August 7, 2017

**Subject: Onejoy Place
Revised Plans & Additional Information**

Terradyn Consultants has prepared revised Site Plans and assembled additional information for Onejoy Place in response to comments from city staff and peer reviewers. A list of plan revisions and additional documents is provided below. The revised plans and documents described herein will be uploaded to the city's electronic plan review system as separate documents.

DATE: 3/7/2017
SCALE: 1" = 10'
DESIGNED: MTW
JOB NO.: 1704
FILE: 1704-BASE.DWG
SHEET **C-3.0**

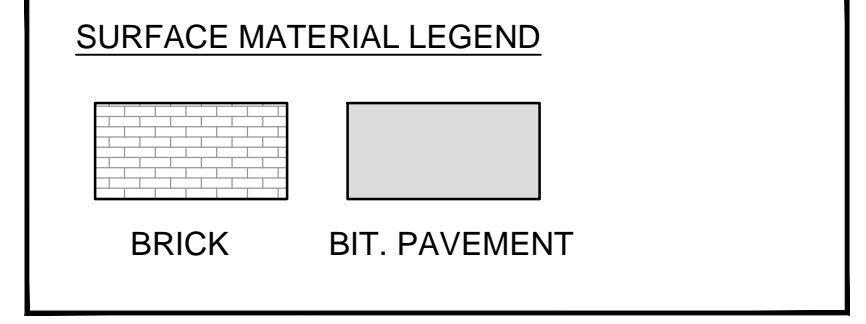
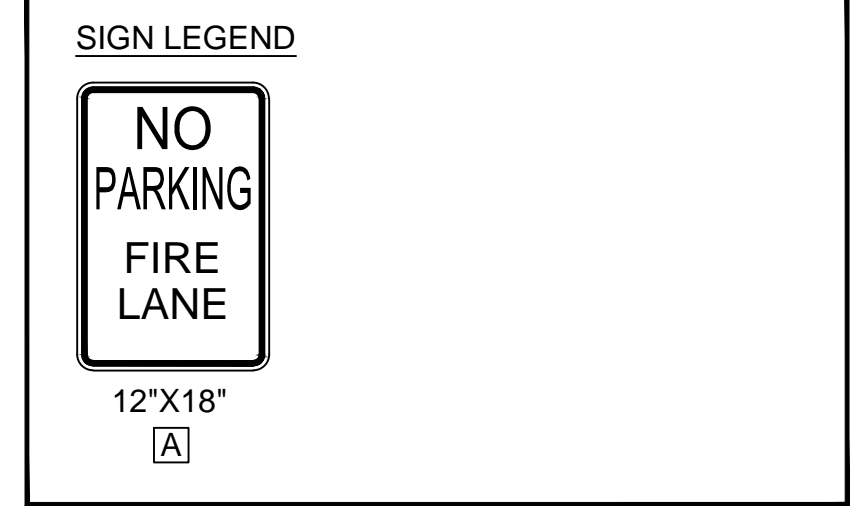
2. At the request of the Portland Fire Department, "No Parking Fire Lane" signs will be installed along Joy Place to prohibit parking within the private right of way. Additionally, the existing parallel parking space serving a resident at 165 Brackett Street will be improved to provide more space and ensure that a car can be parked without encroaching into the Joy Place right of way.

3. Two bike hitches have been added to the end of the proposed sidewalk between Joy Place and 157 Brackett Street. These bike hitches will be located on public property and are intended to be available for public use. Bicycle parking for residents of Onejoy Place will also be located in the basement of the proposed building.
